From: Andrew Hinton [REDACTED]
Sent: 29 October 2014 19:25
To: Janice Chapman
Subject: AW/263/14/HH - Detached outbuilding at 66 Barrack Lane, Aldwick

Re - AW/263/14/HH - Detached outbuilding at 66 Barrack Lane, Aldwick

DRAWING	001 Proposed Scheme	
DATE	15 09 14	
AUTHOR	AH	 SCALE BAR @ 1: 50
STATUS	PL	
SCALE	1: 50 @ A1	
CORINTHIAN ARCHITECTURAL DESIGN		
8 Davys Court, Funtington, Chichester, West Sussex. PO18 9LG 01243 576 078 > contact@corinthianad.co.uk > www.corinthianad.co.uk

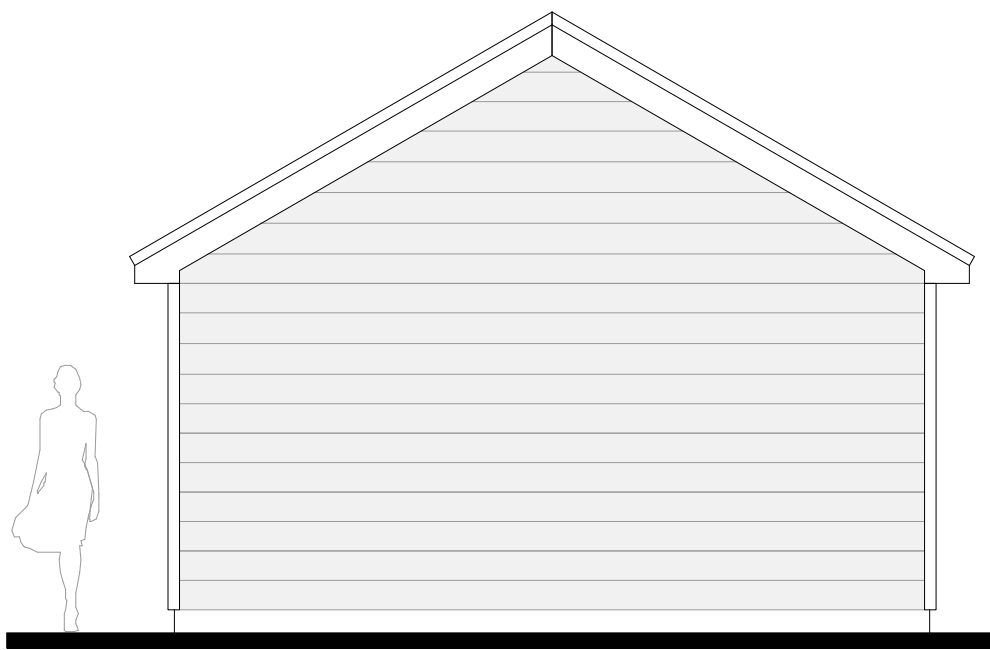
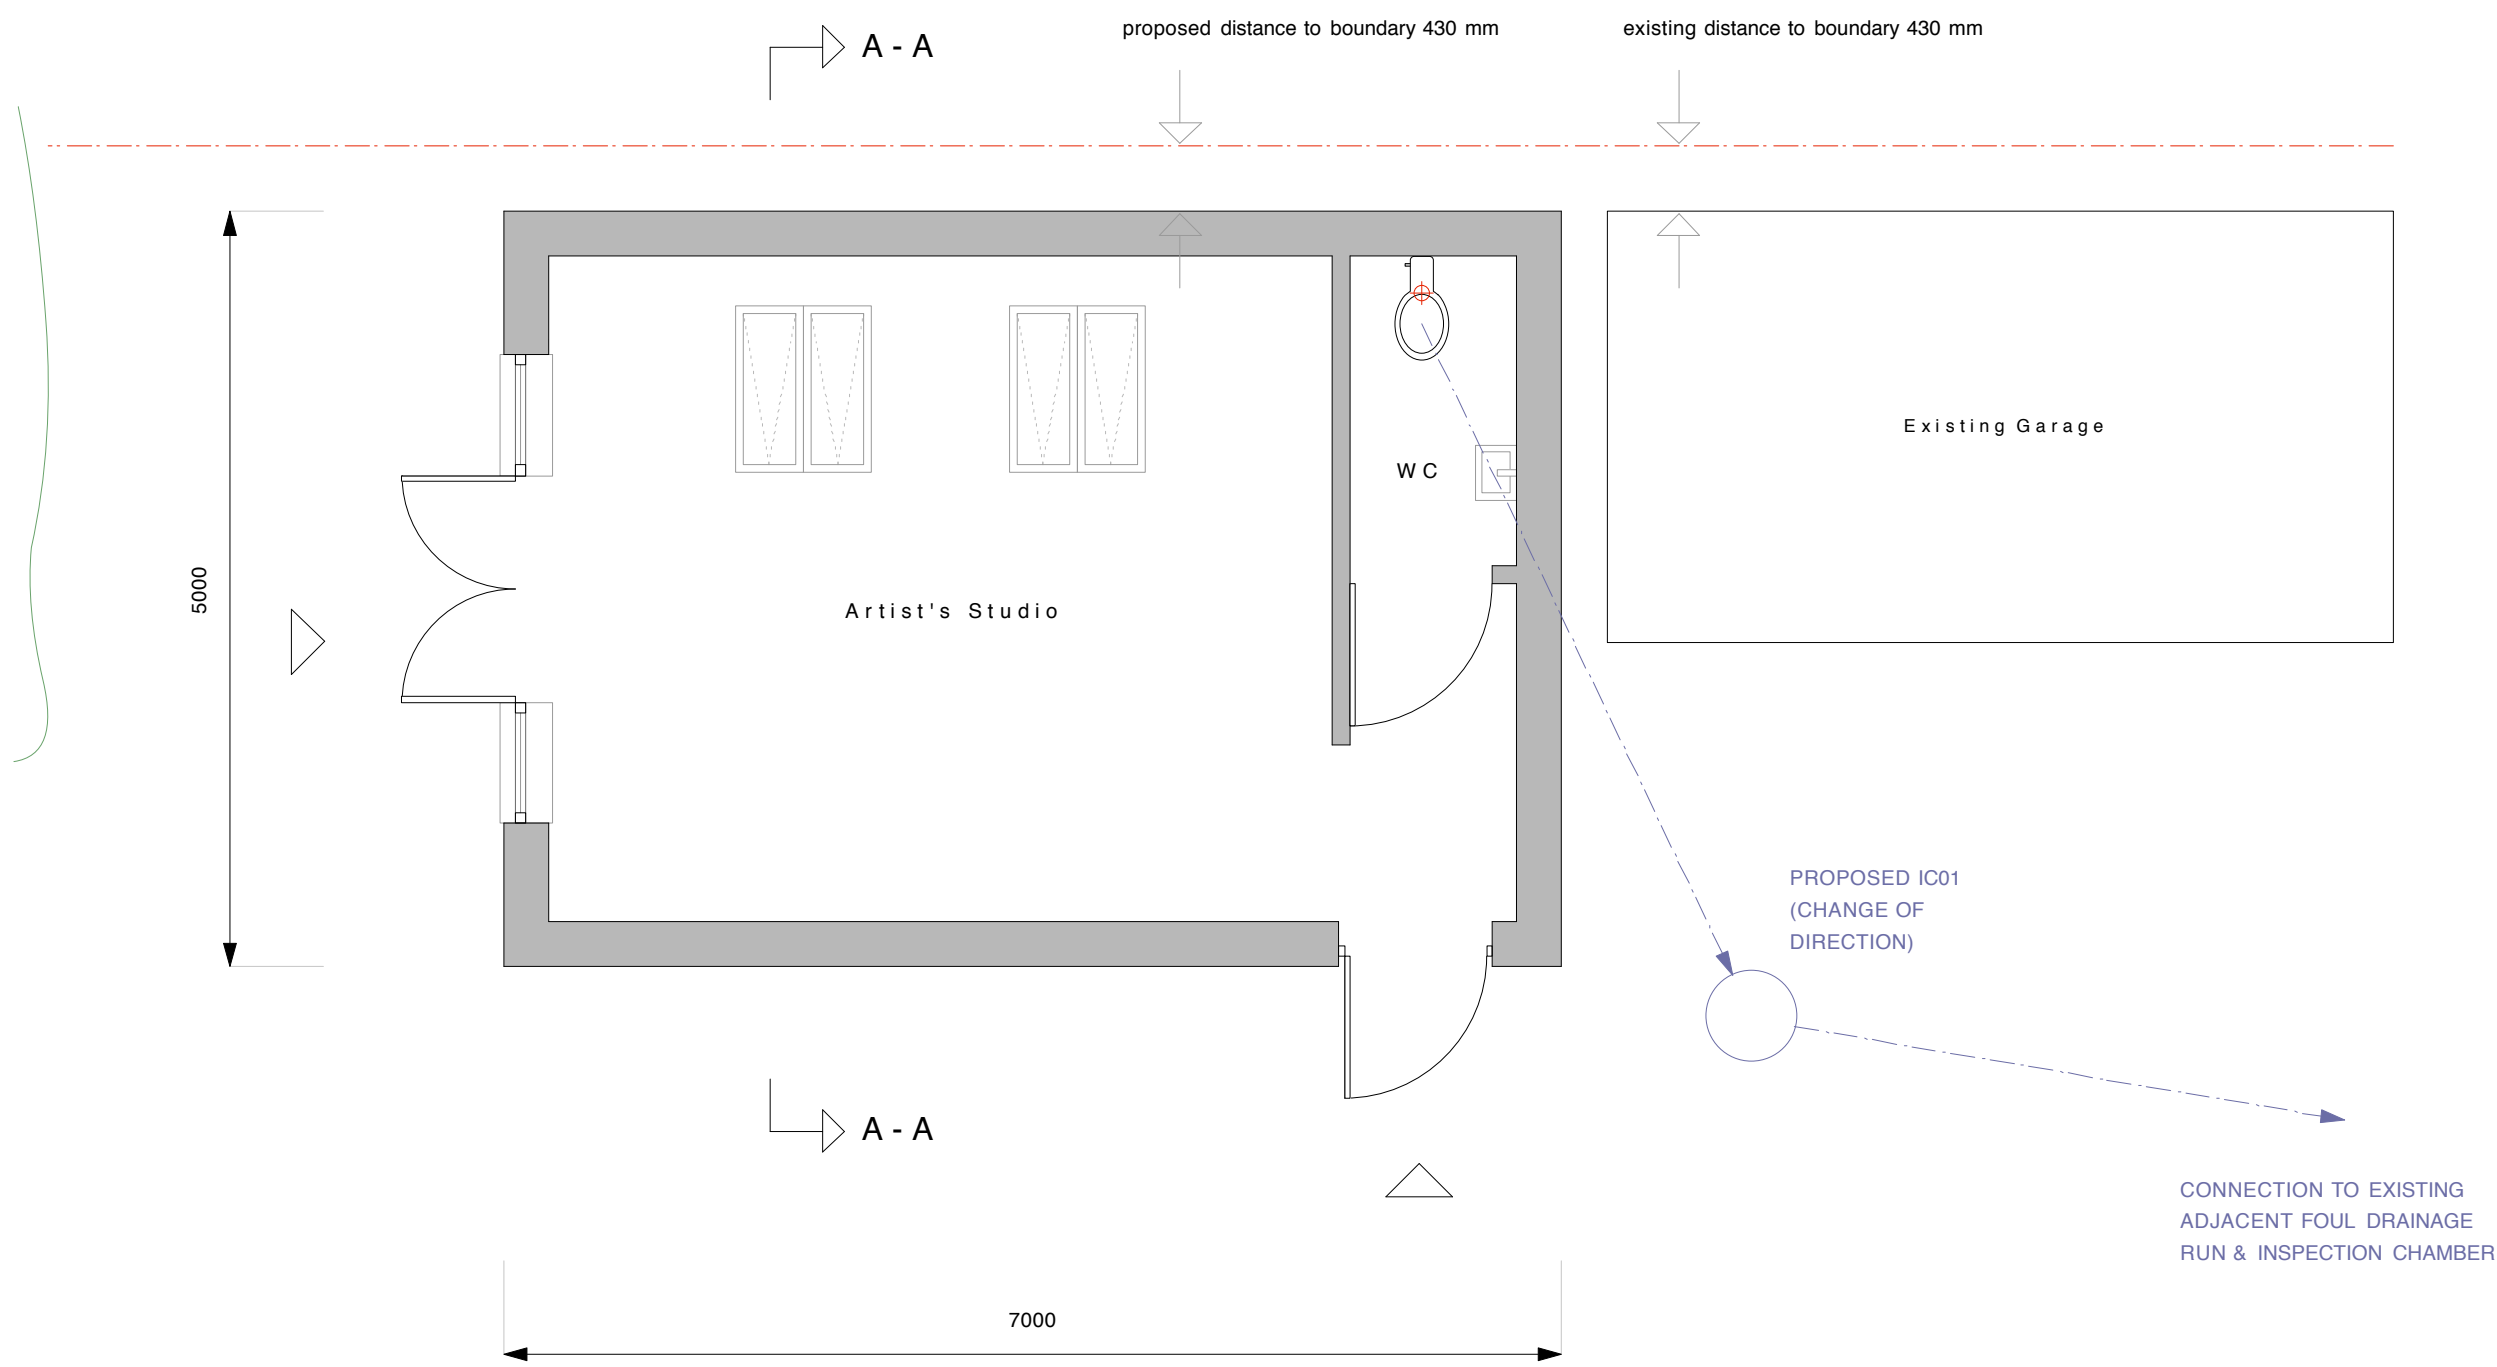
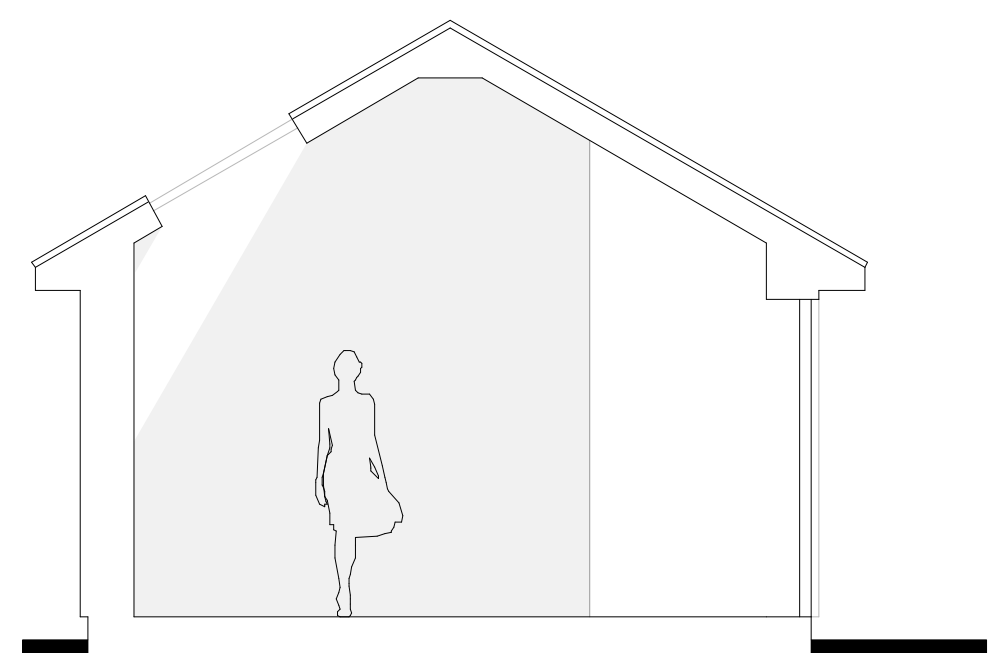
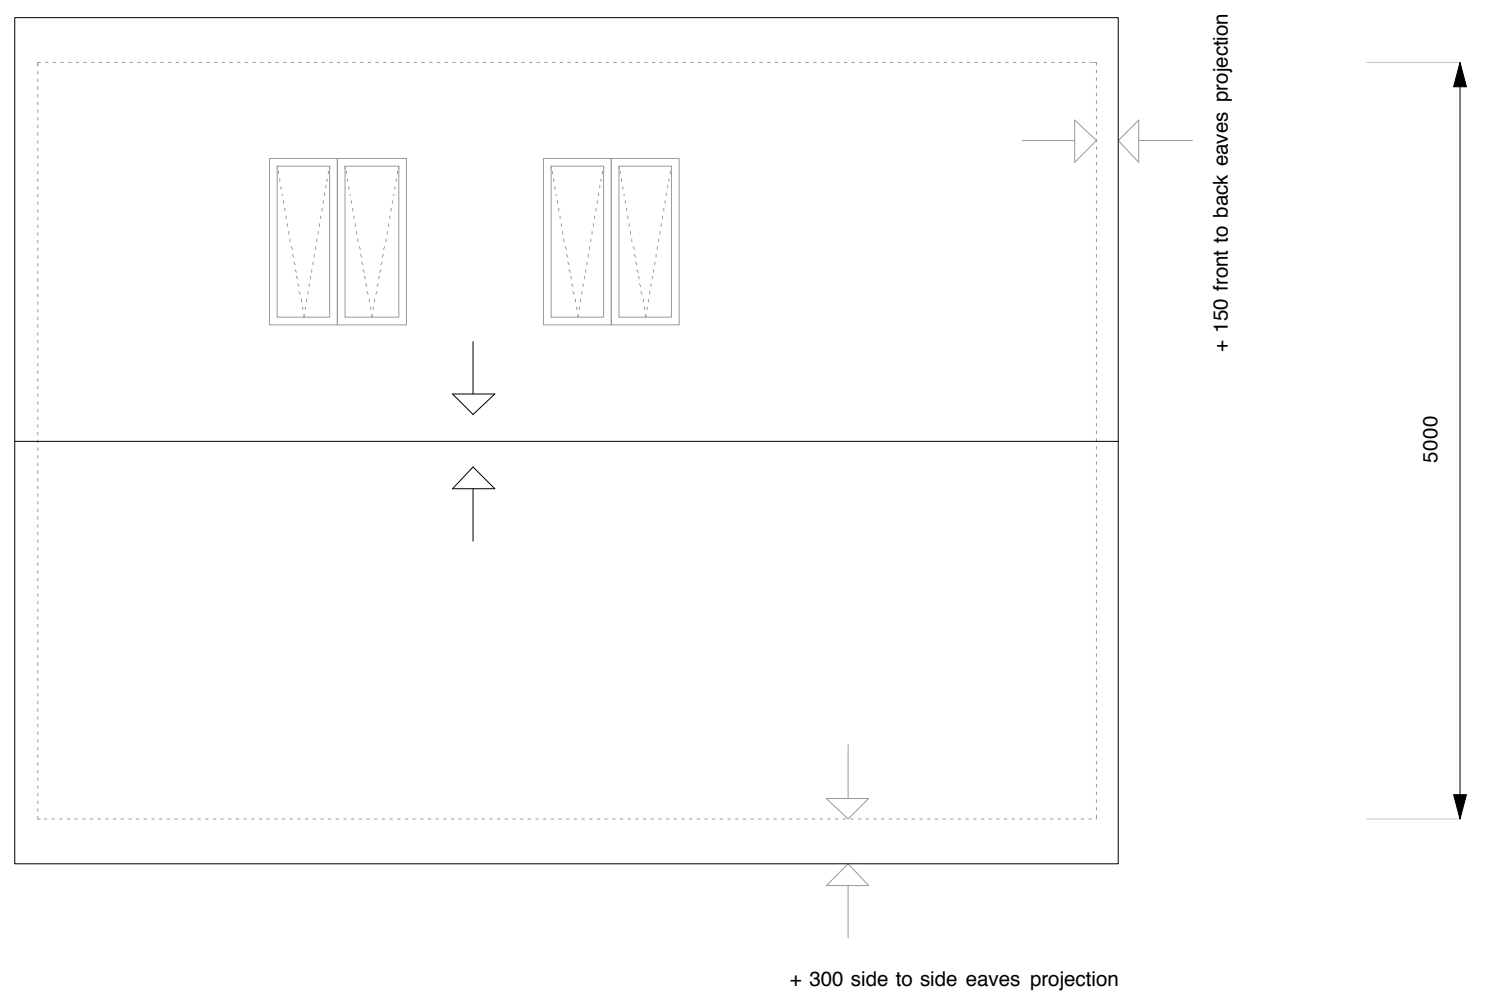
I do not really what to impose a condition regarding the weatherboarding, does your client have a particular colour in mind.

Yes the colour is fine.

Thank you for your message, the Marley Eternit boarding colour proposed is (C10) Blue / Grey. Let me know if this is acceptable?
